Our Ref: EN010085

Date: 14 December 2018

### **Application by Cleve Hill Solar Park Ltd for an Order Granting Development Consent for the Cleve Hill Solar Park**

#### **Advice Following the Issue of Decision to Accept the Application for Examination**

CROWN LAND PLAN

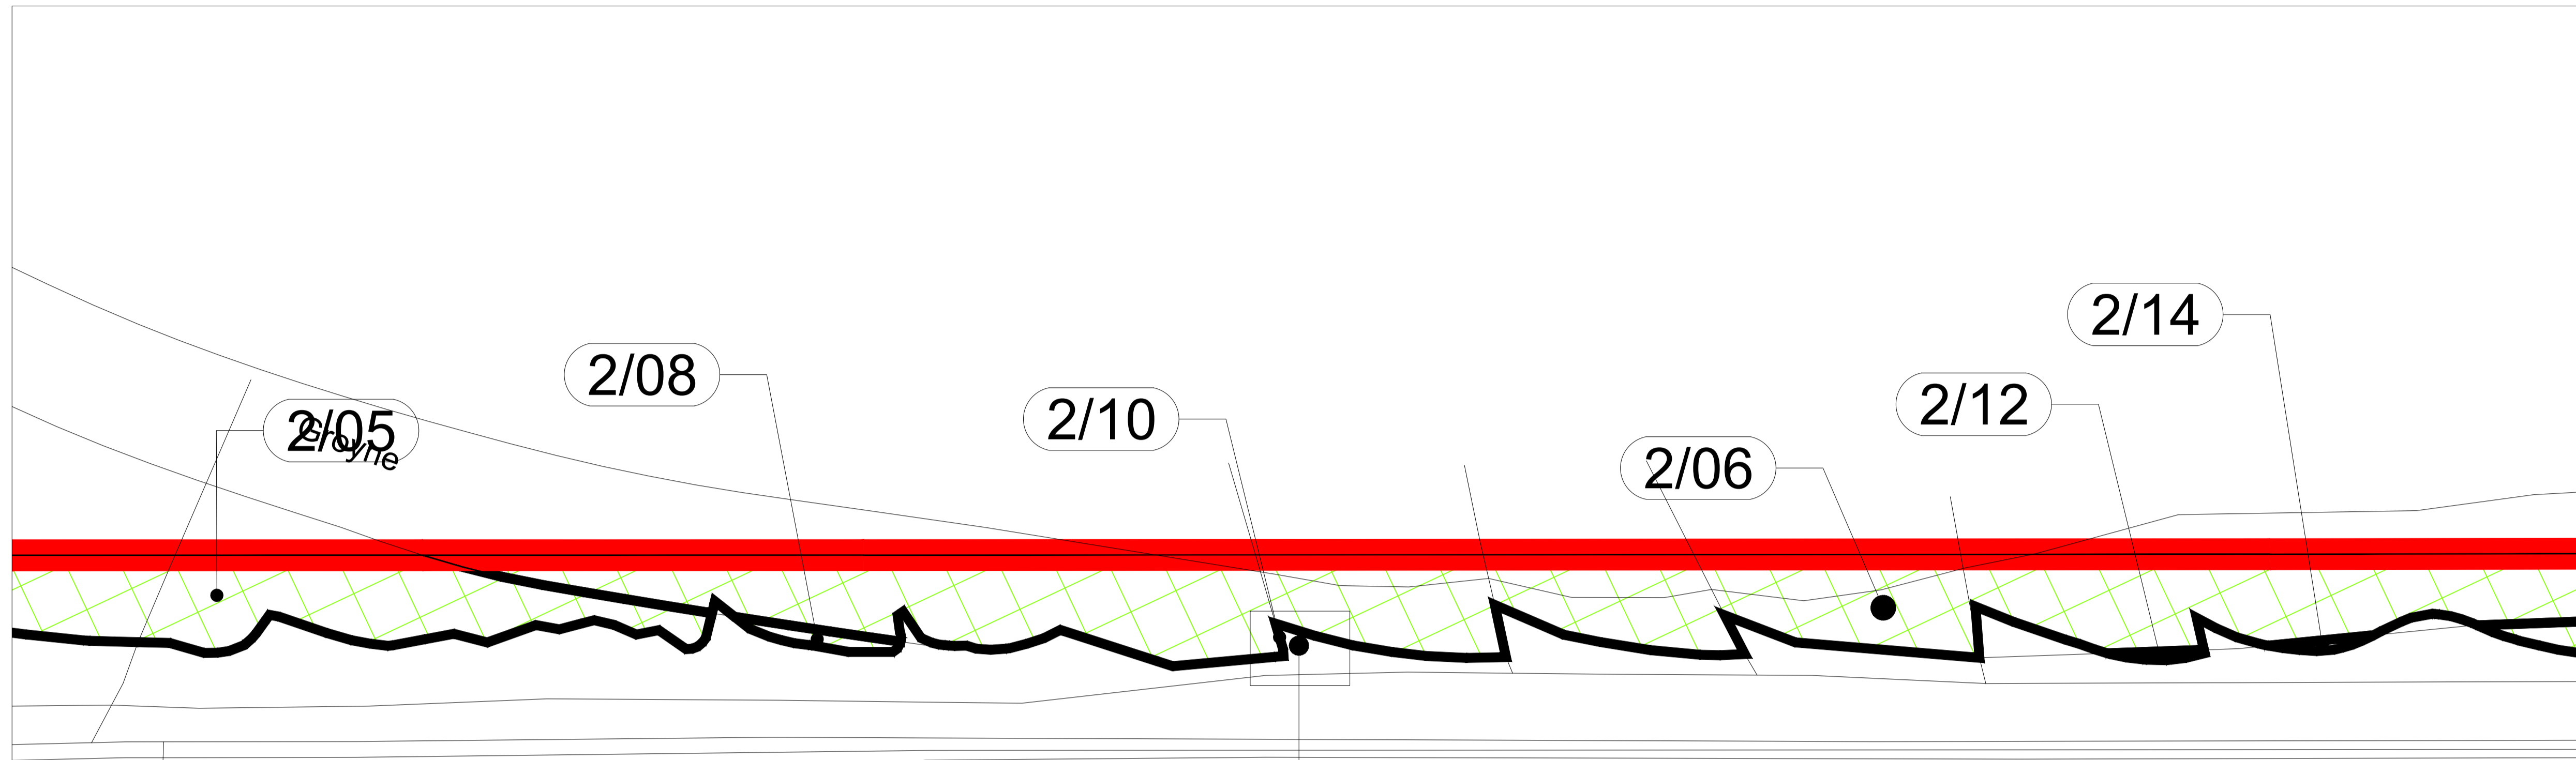
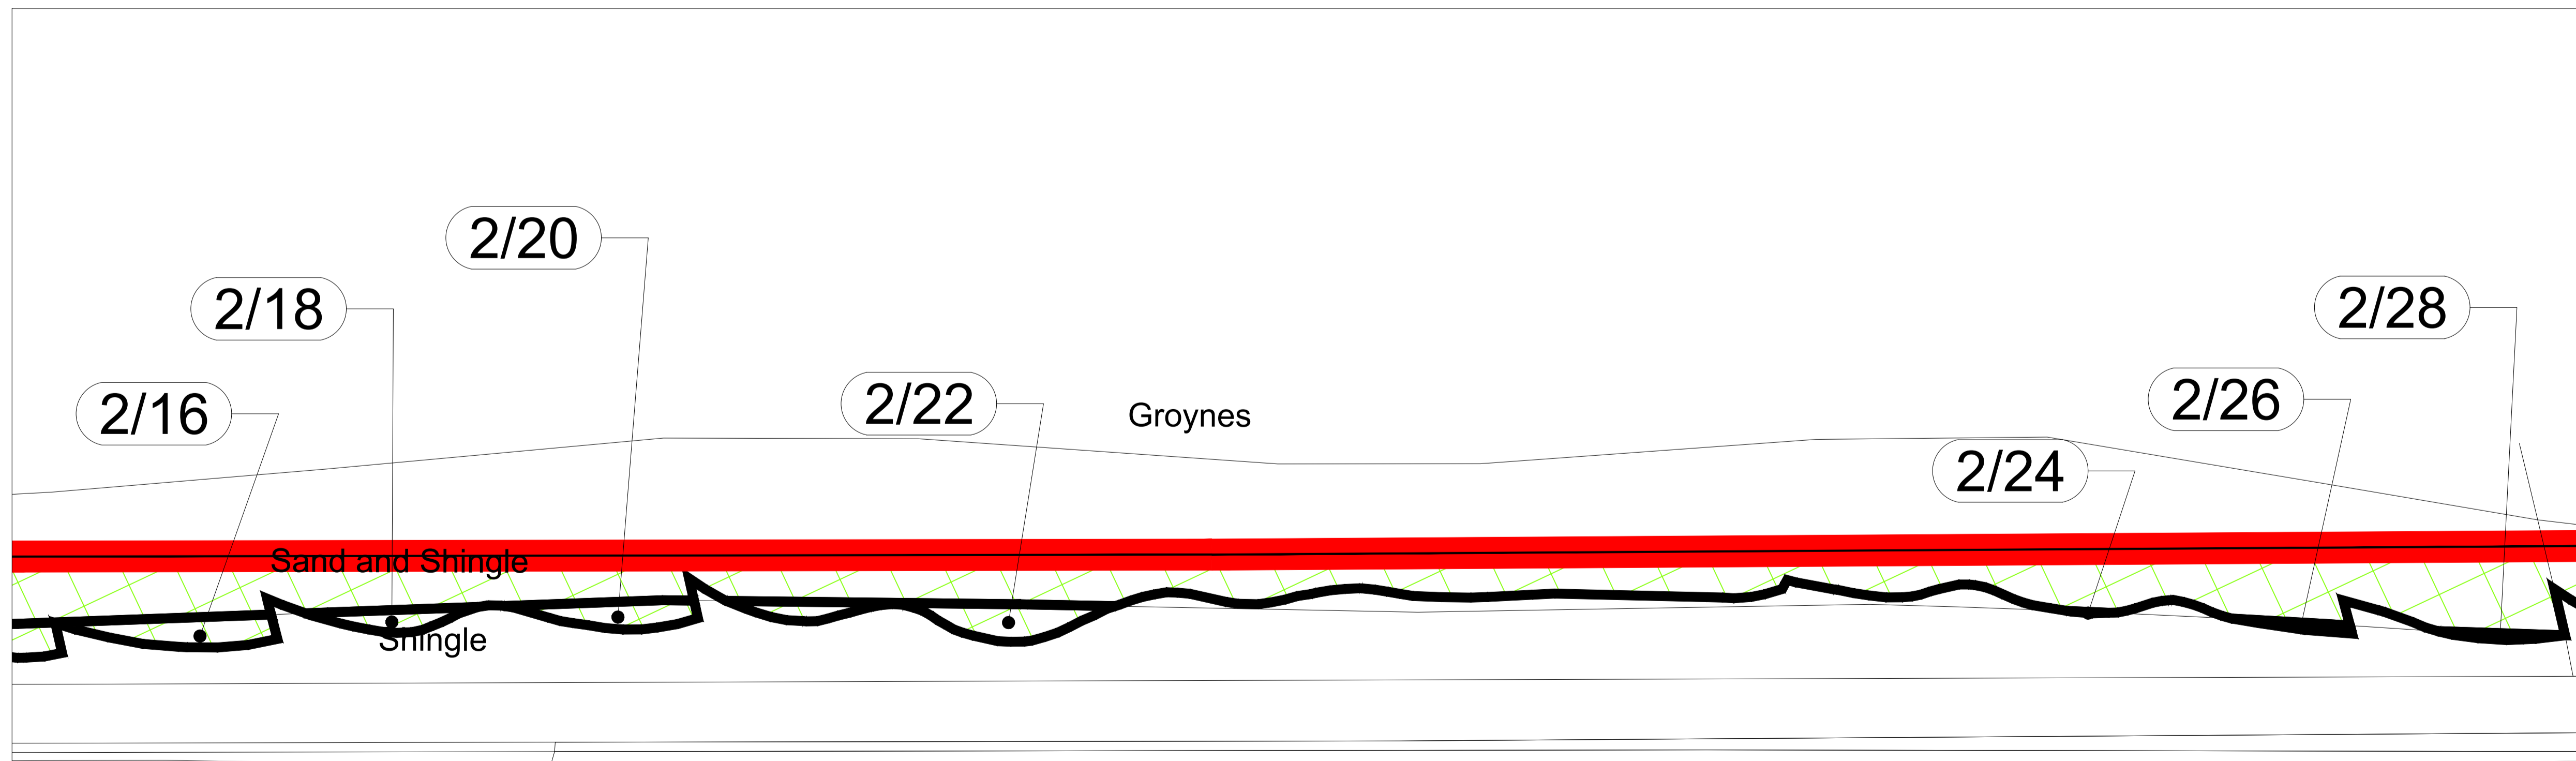
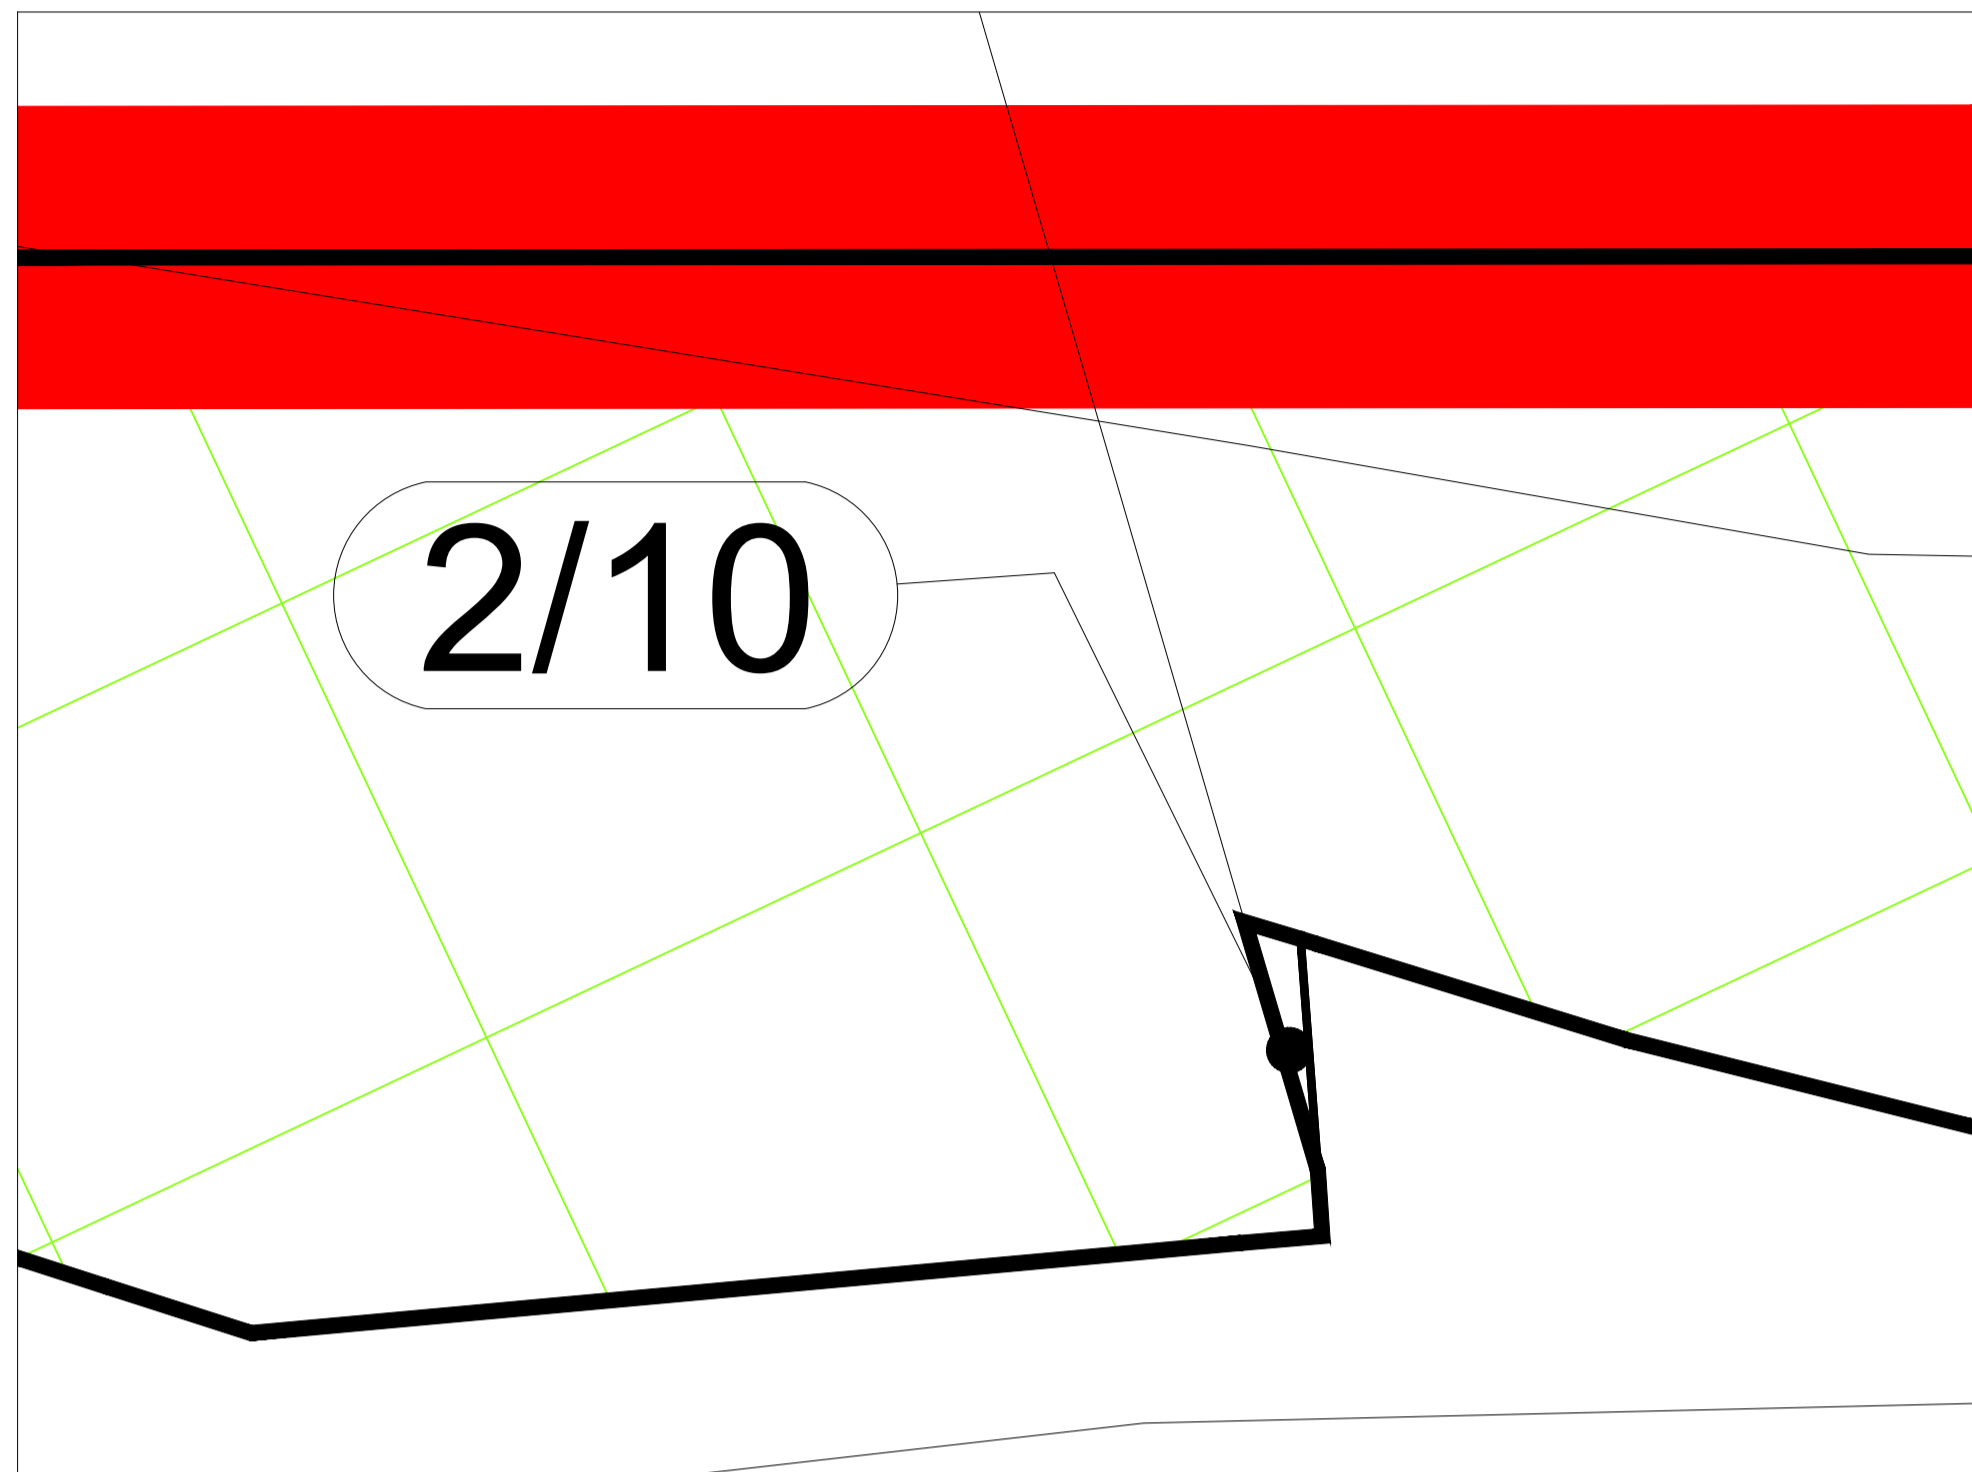
The Inspectorate has noted that the inset sections detailing the smaller plots (used on the land plans (**Doc Ref 2.1**)) are missing from the Crown Land plans. This can make seeing the affected plot difficult without also viewing the land plans. Please can the Applicant provide clarity on this.
